**SSD\_7054: LEES 1 BUILDING AND SSD\_7055: F23 ADMINISTRATION BUILDING**  
**UNIVERSITY OF SYDNEY RESPONSE TO SUBMISSIONS**

The University of Sydney has reviewed all submissions received during the statutory public exhibition period of State Significant Application *SSD 7054 – F07 LEES 1 Building* and the *SSD 7055 – F23 Administrative Building*, both located on the southern edge of the University's Camperdown campus fronting City Road.

11:00 AM - WINTER SOLSTICE

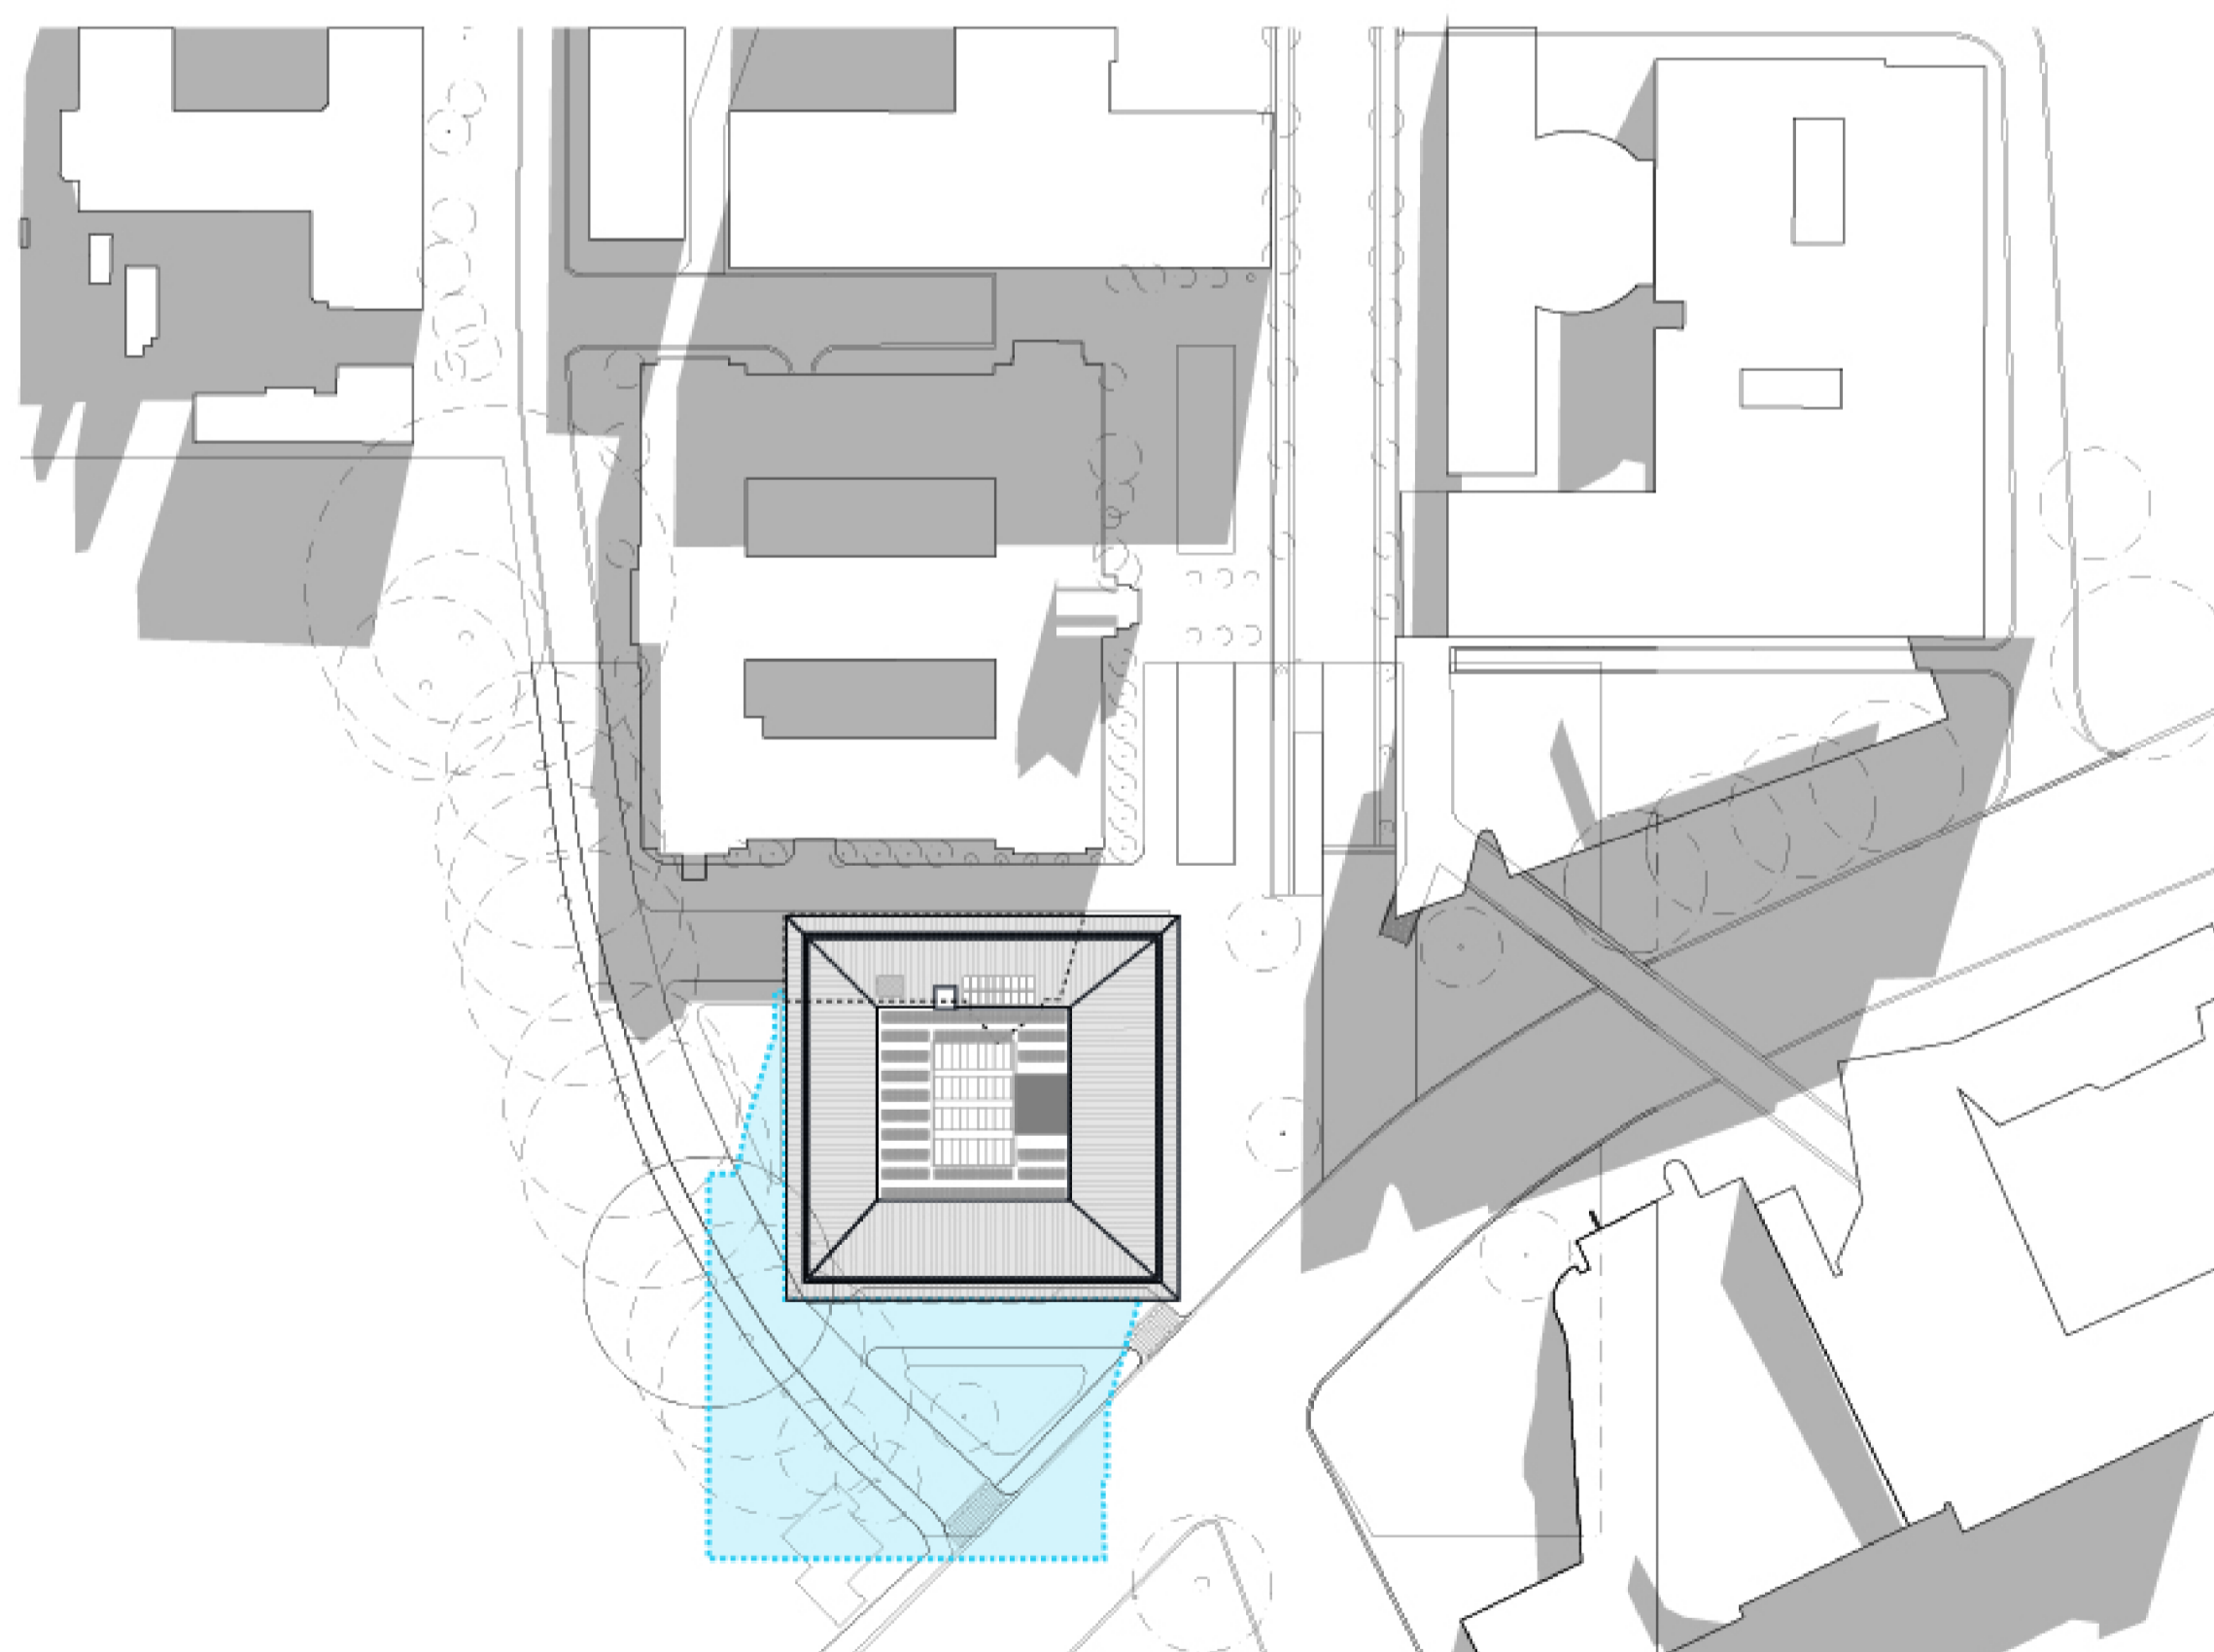
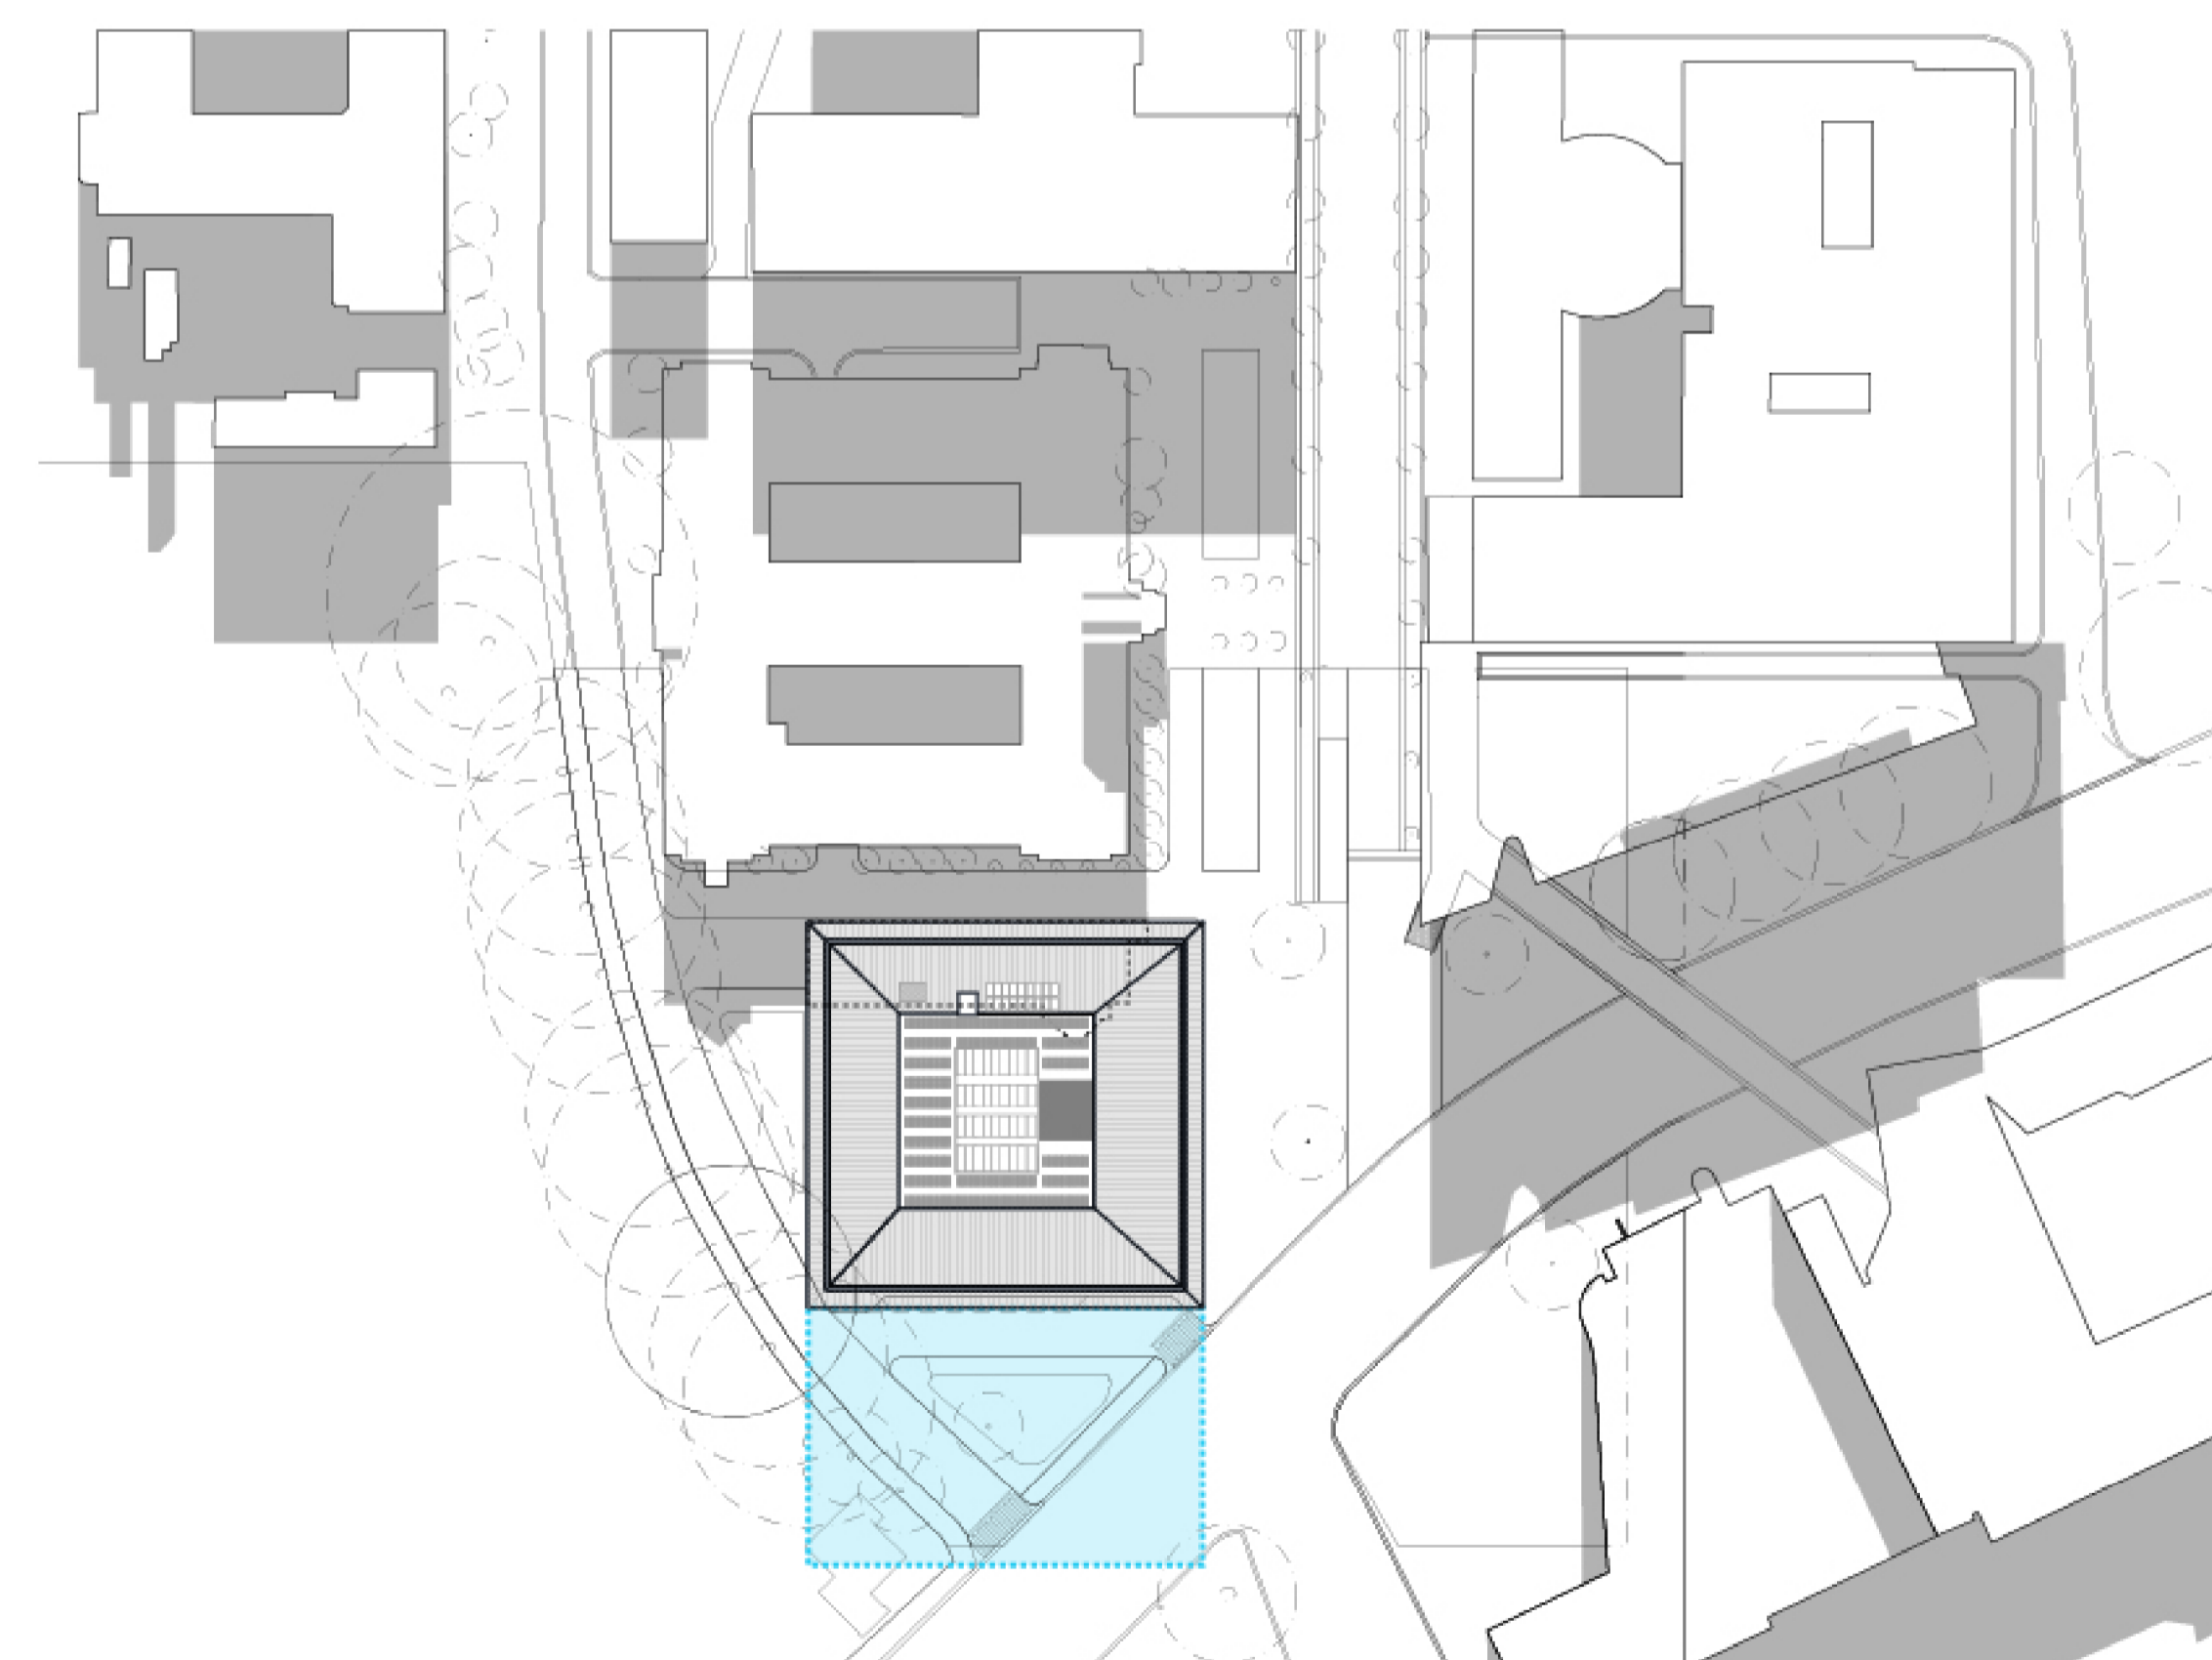
<p><b>8. Overshadowing</b></p> <p>Detailed diagrams are required to differentiate the existing shadow from that of the shadows cast by the proposal.</p>	<p>Amended shadow diagrams have been updated and included in <b>Appendix 01.03</b>.</p>
<p><b>9. Flooding</b></p> <p>The site is subject to flooding. The recommended finished floor levels specified in the Flood Report must be applied to the proposed development and thus comply with the City of Sydney Interim Floodplain Management Policy.</p> <p>As there are a number of stormwater upgrades proposed, a stormwater quality assessment should be provided in accordance with the Sydney DCP 2012 requirements.</p>	<p>Flood levels have been provided as per the civil stormwater report dated 16 March 2016.</p> <p>The finished floor levels are required to be 500mm above the levels as specified i.e. FFL 35.70 (proposed FFL 35.75) at entrances’ to the western side, and FFL31.80 (proposed FFL 32.10) on the eastern (Barff Rd) side, thus complies with the City of Sydney’s Interim Floodplain Management Policy. Refer to the attached drawings indicating the proposed FFLs.</p> <p>With respect to the water quantity, since the issue of the report, the stormwater strategy has changed in that we are now discharging to the Council/ Sydney Water system in City Road rather than the University of Sydney’s downstream network. The University is required to comply with parameters that Sydney Water has sent is in terms of OSD volume (37m<sup>3</sup>).</p>
